Application for a non-material amendment following a grant of planning permission.  
 Town and Country Planning Act 1990

Two storey side & rear extension & single storey rear extension

DM/22/00321/FPA

## 8. Non-Material Amendment(s) Sought

Project	Woodsmoor Pittington Rd Rainton Gate DH5 9RG
Content	Plans as Proposed
Date	Jan 2022
Scale	1:100 @ A3
Drwg No.	MAD 489/2 / 'A'

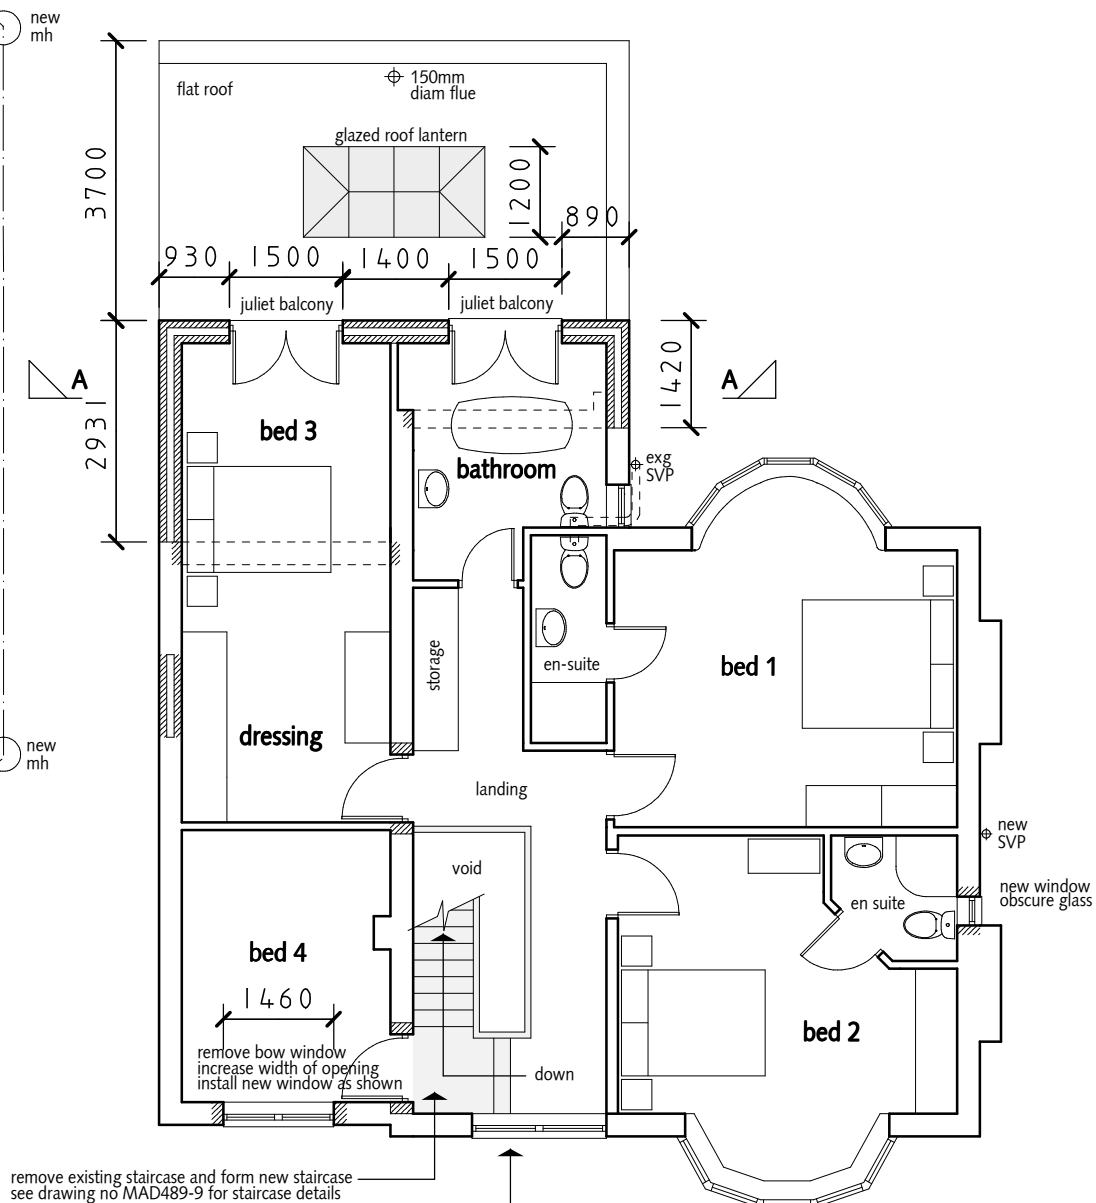
x2 sets of french doors added to replace single set of doors to Kitchen Diner  
Bay window to office replaced with flat window  
Bay window to Bedroom 4 replaced with flat window  
First floor landing bay window replaced with flat window  
width of french doors to bedroom increased to 1500 mm  
Existing brickwork to lower half of property rendered to match existing
